RESPONSE TO SUBMISSION CLAUSE

In response to the issues and concerns raised by the DP&I, other government agencies, third party commercial stakeholders and residents. A number of changes have been made to the proposed development in response to these concerns and these changes are listed in the Table 1 below and shown on the revised Architectural Plans prepared by COC Architecture (Appendix B)

The University of Sydney - Engineering & Technology Precinct

Stage 1

A-DA-1111

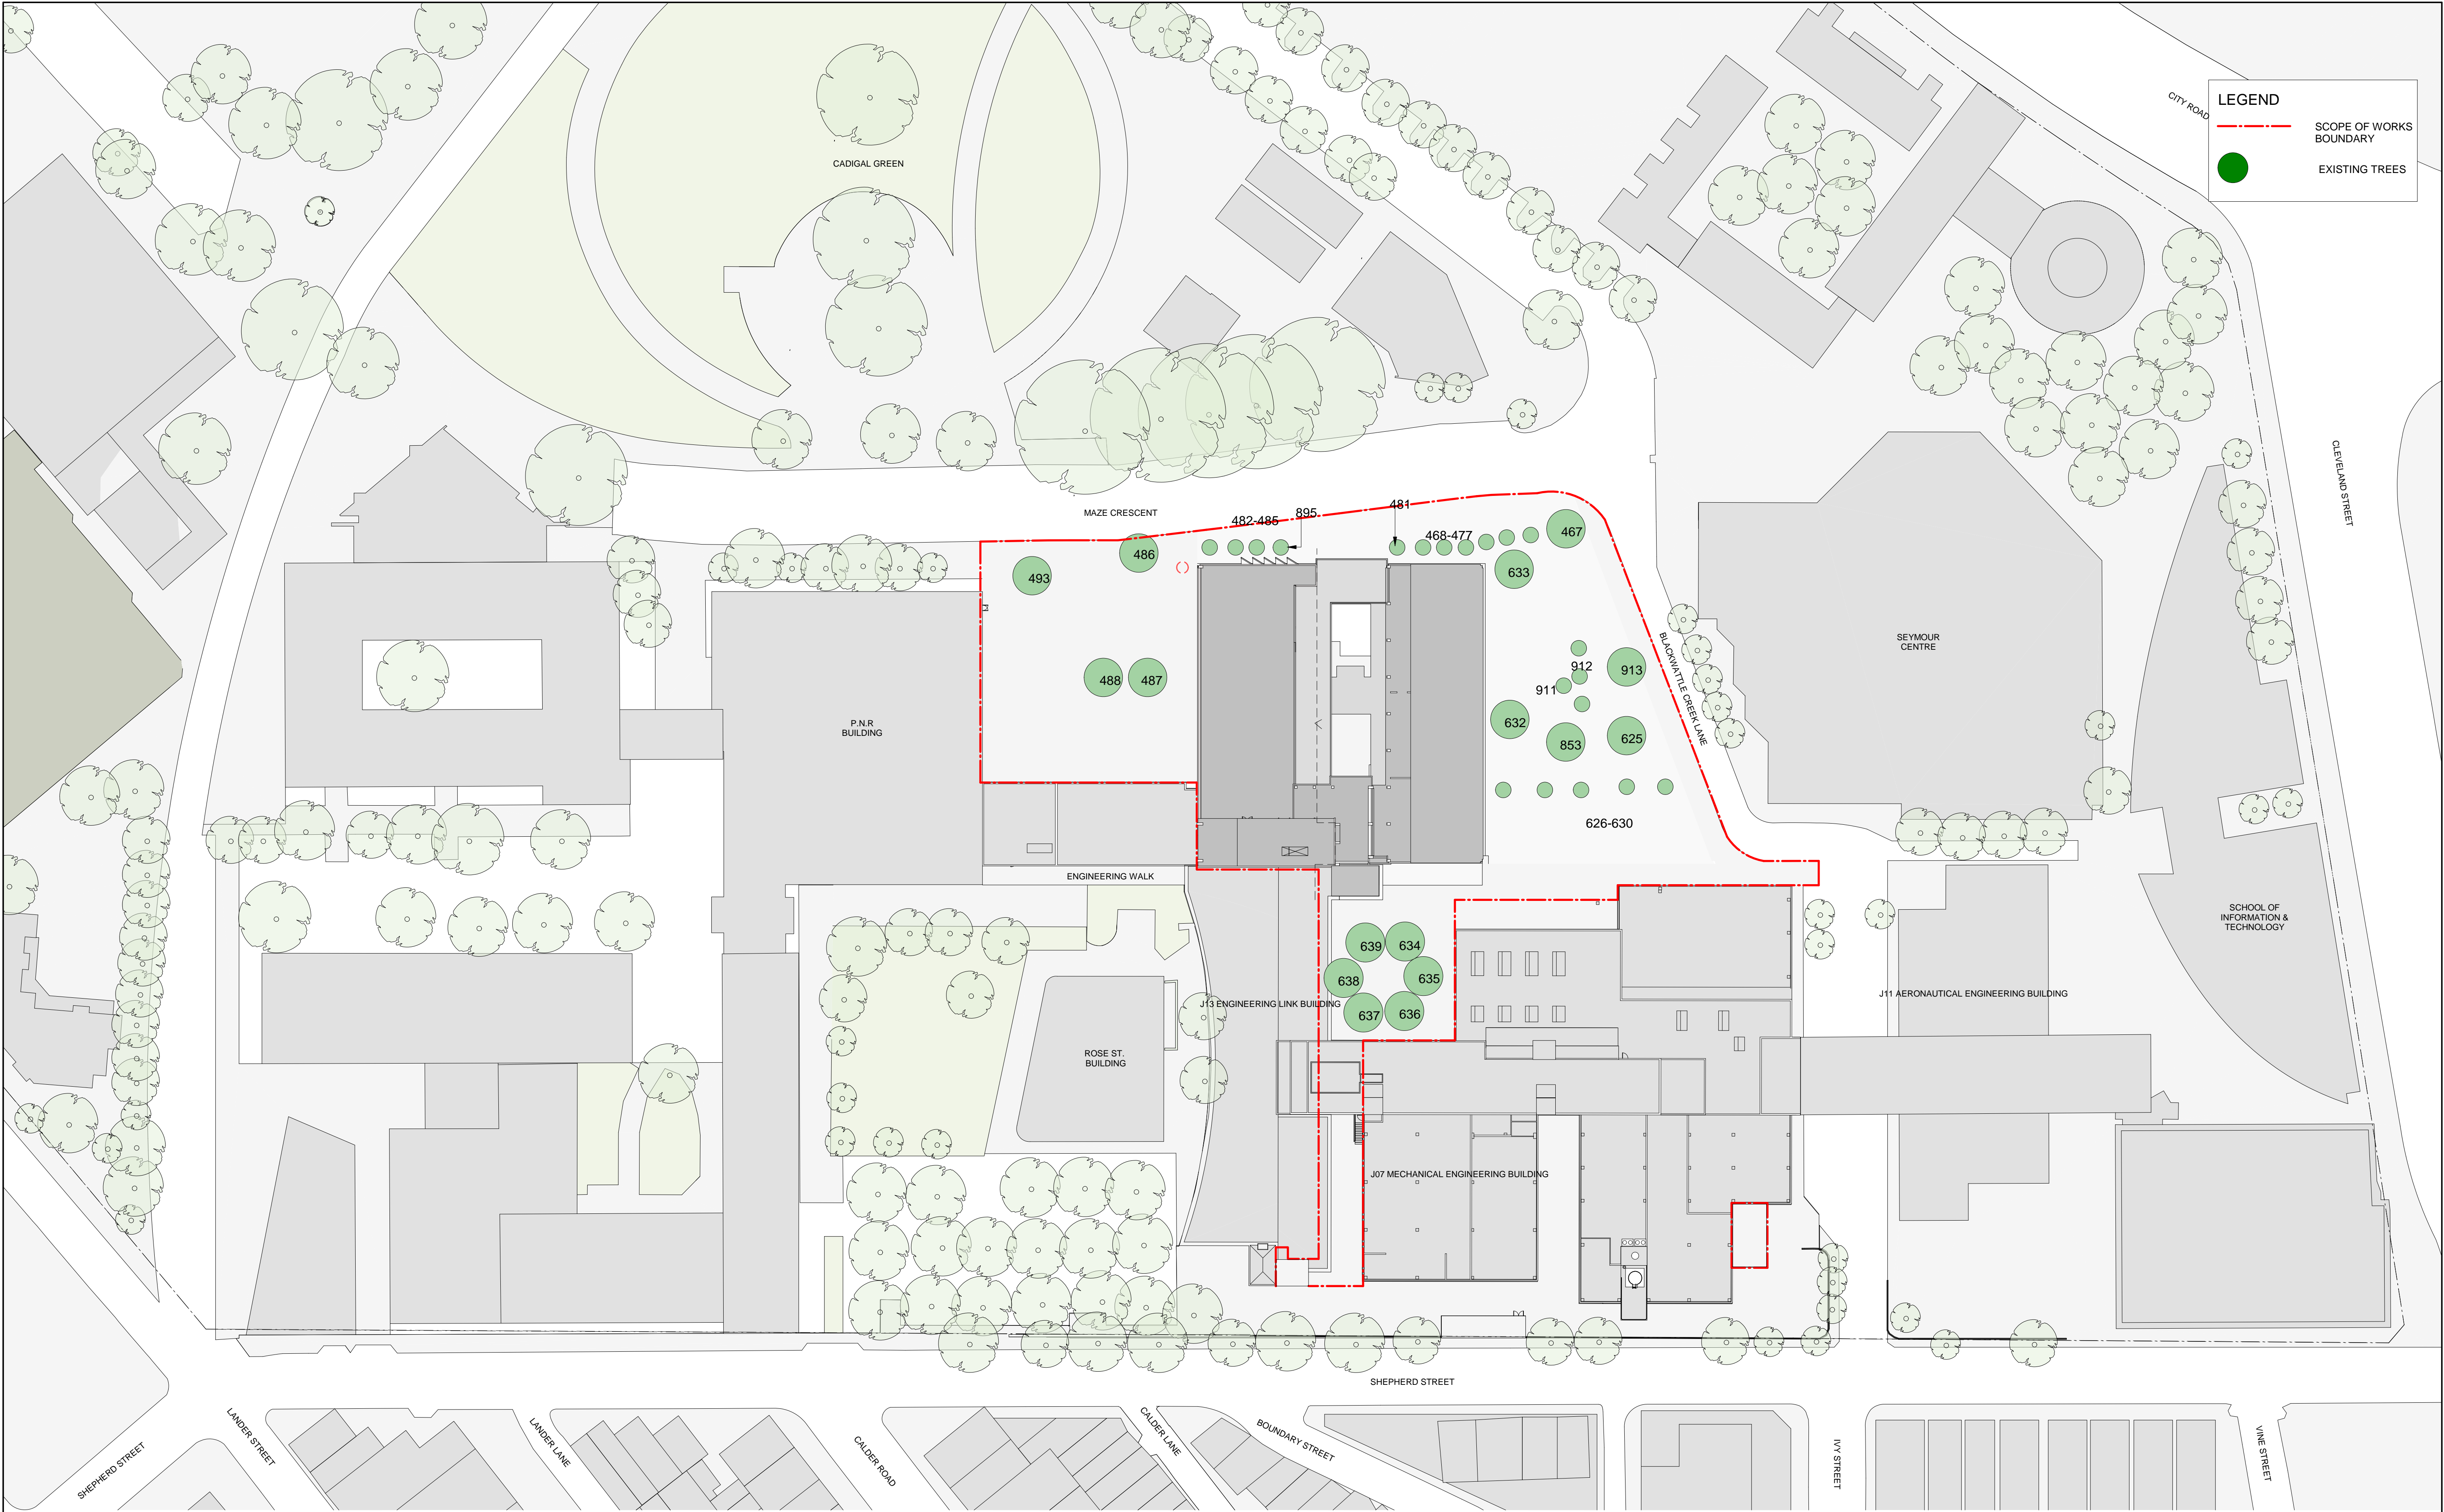
DRAWING NUMBER	DRAWING NAME	REVISION	DETAILED DESIGN CHANGES	RELEVANT TO RESPONSE TO SUBMISSION
A-DA-0101	COVER SHEET / DRAWING INDEX	D	• Drawing list updated • 3D view updated	
A-DA-1111	SITE ANALYSIS PLAN	D	• Landscaping updated • Scope of work boundary updated • V.I.E. enclosure relocated	• 3.16 VIE • 3.16 VIE
A-DA-1121	SITE PLAN - EXISTING	D	• Scope of work boundary updated • V.I.E. enclosure relocated	• 3.16 VIE • 3.16 VIE
A-DA-1122	SITE PLAN - PROPOSED	D	• Landscaping updated • Scope of work boundary updated • V.I.E. enclosure relocated	• 3.16 VIE • 3.16 VIE
A-DA-2101B	FLOOR PLAN - LEVEL 01 (SHEET 02 OF 02)	D	• Relocation of V.I.E. enclosure	• 3.16 VIE
A-DA-2102	FLOOR PLAN - LEVEL 02	D	• End of trip facilities (2 showers) added • Updated bike rack count • Deletion of engineering walk awning • Addition of risers along grid 06	• 3.14 - End of trip facilities • 1.06 - End of trip facilities
A-DA-2103	FLOOR PLAN - LEVEL 03	D	• Updated stair at western end • Deletion of the portals and engineering walk awning • Landscaping updated • Risers added along grid 06

Project
THE UNIVERSITY OF SYDNEY ETP STAGE 1
Electrical Engineering Building
University in Darlingtown, NSW 2008
Drawing Title
FLOOR PLAN - LEVEL 04

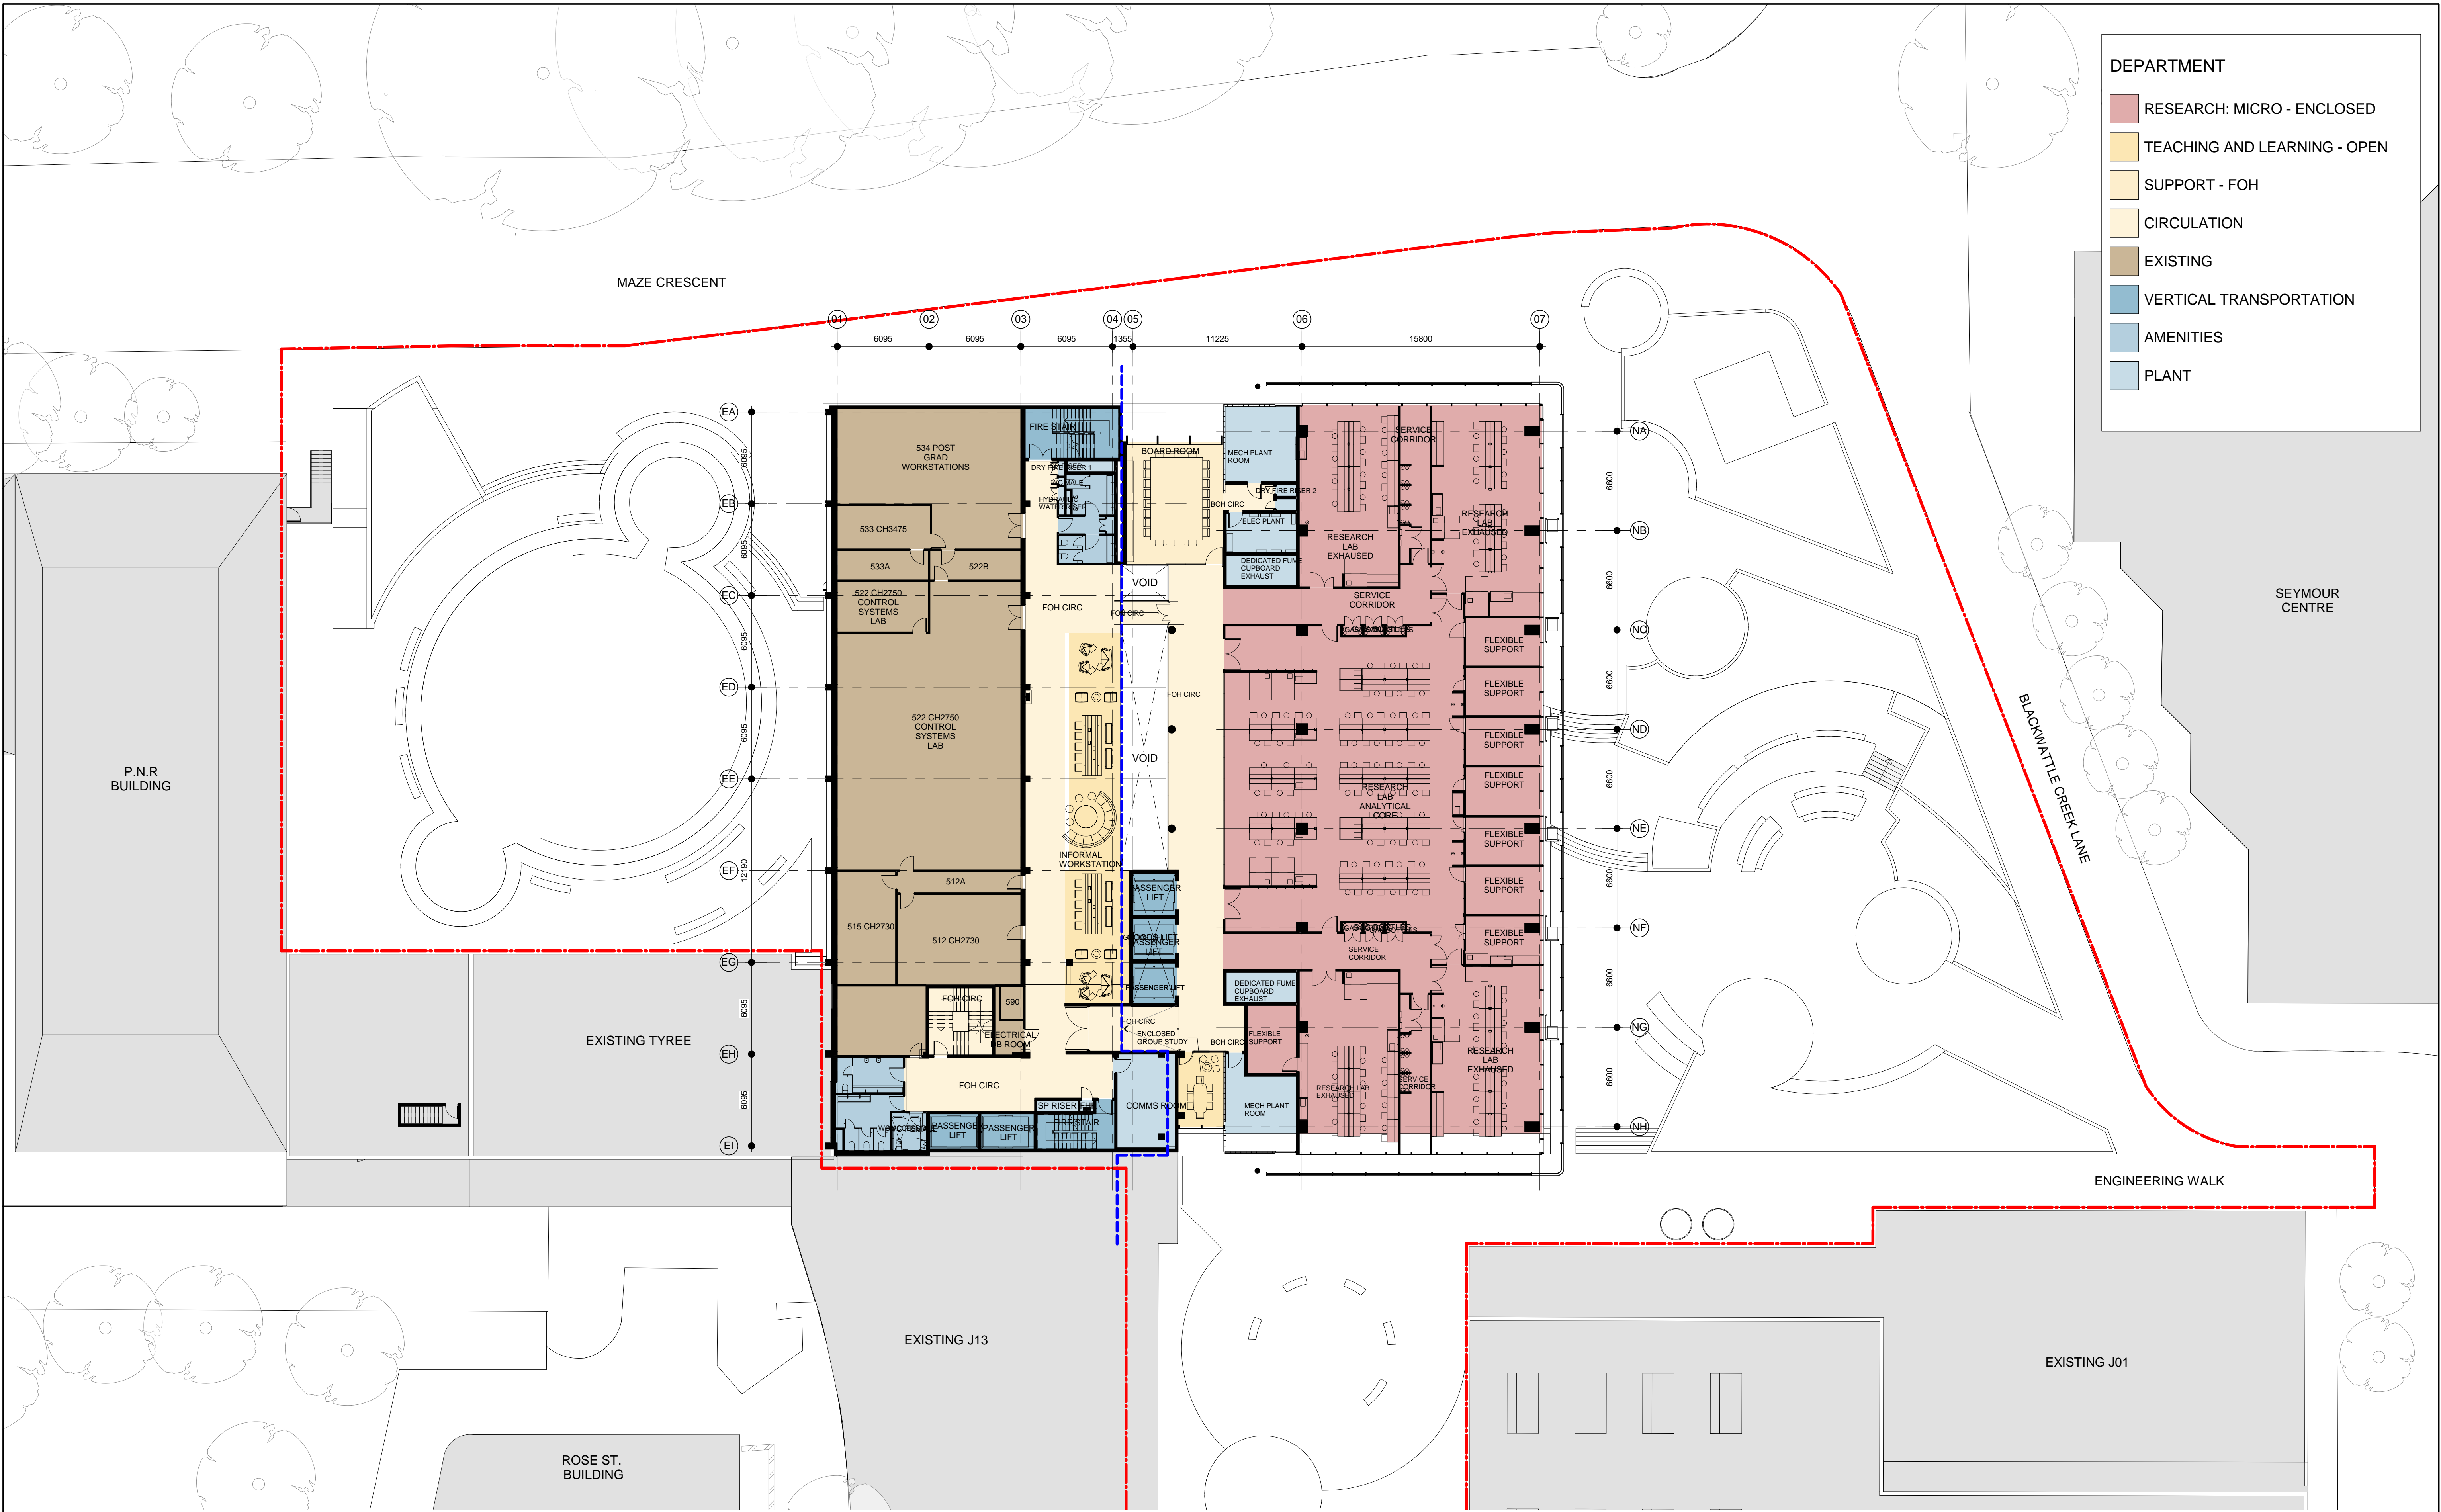
A-DA-2104	FLOOR PLAN - LEVEL 04	D	• "Interconnecting accommodation stair" annotation added • "& School hub" added to the name of room name 448 • Department filled region extent amended to suit floor plate • Landscaping updated	
A-DA-2105	FLOOR PLAN - LEVEL 05	D	• Department filled region extent amended to suit floor plate • Riser along grid 06 added • Landscaping updated	
A-DA-2110	FLOOR PLAN - LEVEL 10	D	• Stair along grid NG relocated	
A-DA-2111	FLOOR PLAN - LEVEL 11,12,13	D	• Roof geometry amended • Solar panel array added • Hot water panel array added	• 3.10 ESD
A-DA-3001	NORTH ELEVATION	D	• Landscaping updated • Engineering walk awning deleted • In the legend, "polycarbonate panel" replace by "glass plank"	
A-DA-3001A	3D VIEW - NORTH	B	• 3D view replaced	
A-DA-3002	SOUTH ELEVATION	D	• Feature screen amended and added • Glass plank deleted and replaced by full height curtain wall	
A-DA-3002A	3D VIEW - SOUTH WEST	B	• 3D view replaced
